From: planning@welhat.gov.uk
To: [Planning Comments \(Shared Mailbox\)](#)
Subject: New comments for application 6/2019/2714/OUTLINE
Date: 14 December 2020 12:53:16

New comments have been received for application 6/2019/2714/OUTLINE at site address: One YMCA, 90 Peartree Lane, Welwyn Garden City AL7 3UL

from Gerry Brophy gerry.brophy@herts.pnn.police.uk

Address:
Architectural Liaison Officer
Hatfield Police Station
Comet Way
Hatfield
AL10 9SJ

FIG 31. BRICK DETAILS AROUND WINDOWS AND GABLED ENTRANCE FEATURE

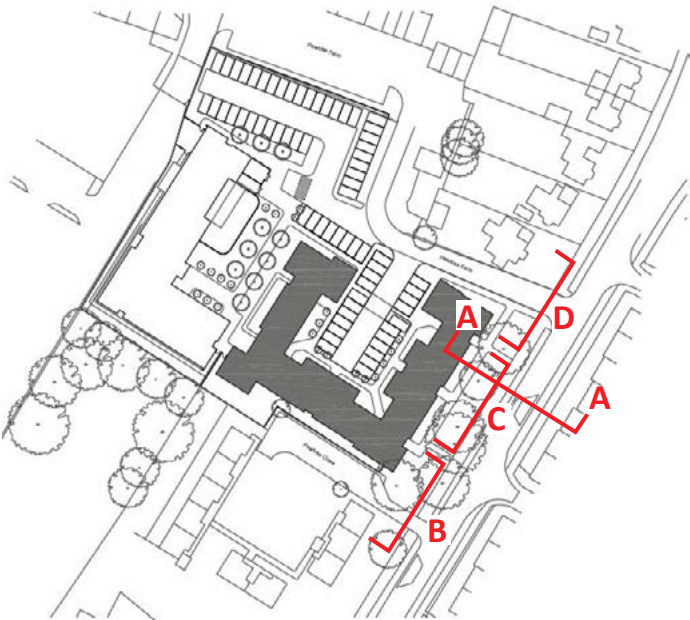
Thank you for sight of this application on which I have previously commented. The desire to include advice from Secured by Design (SBD), is to be commended, but I note no such comment relating to the residential element of the application. The indicative design shows a brick pattern by the entrance to the hostel which would allow for very easy access to the window above. This is not good design. All three stairwells accessing the residential units have a recess to the rear of the stairwell with a window installed. These areas are potential crime drivers as they allow for people to meet out of sight and conduct business through the windows! The external recessed areas are often rubbish traps with potential for arson attack and do not serve any obvious purpose and therefore should be eliminated. I reserve the right to comment further at the detail stage, but at this time I continue to support this application.
